**REQUEST**

Current Zoning: R-3 (single family residential)  
 Proposed Zoning: MX-2 (mixed use)

**SUMMARY OF PETITION**

**STAFF RECOMMENDATION**

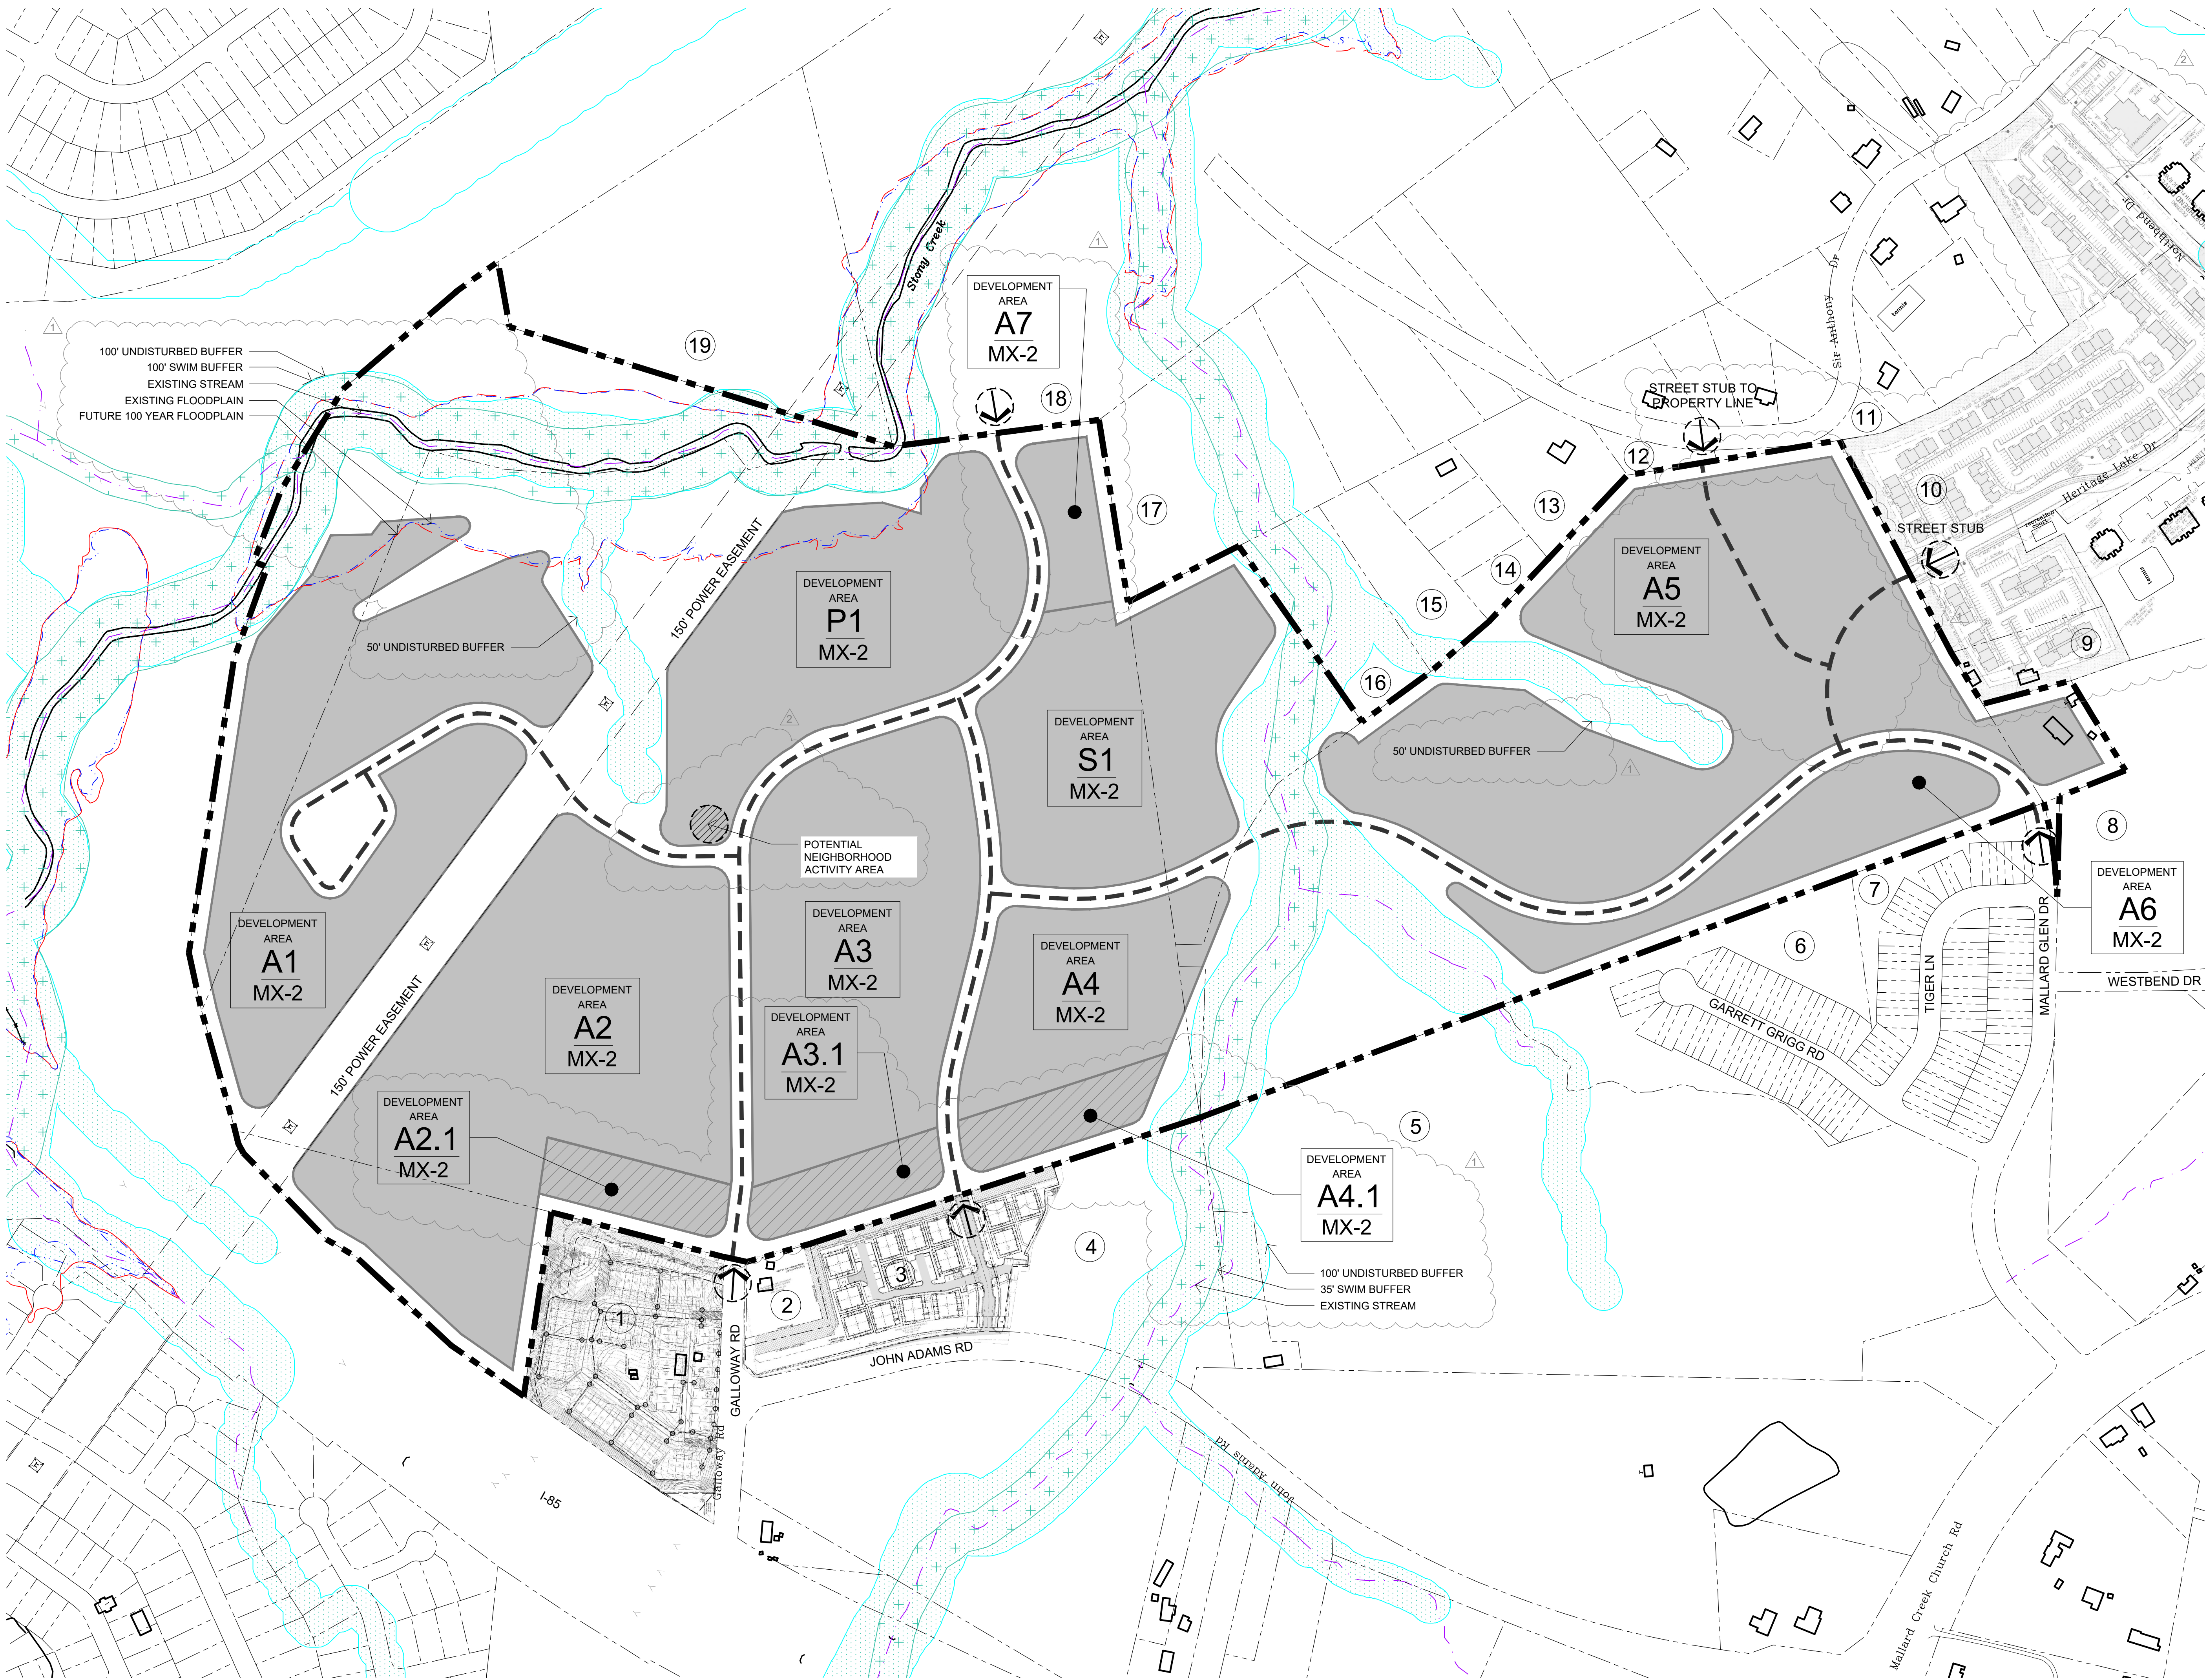
1. Provide a non-residential component that would provide neighborhood supportive uses.
2. Commit to a more defined count of units by unit type.
3. Commit to a number of unit types that better align with the N1 Place Type such as single-family detached, duplexes and triplexes.
4. Revise development areas to make them clearer (e.g., Development Area A, B, C).
5. Label development areas on the plan to list the uses.
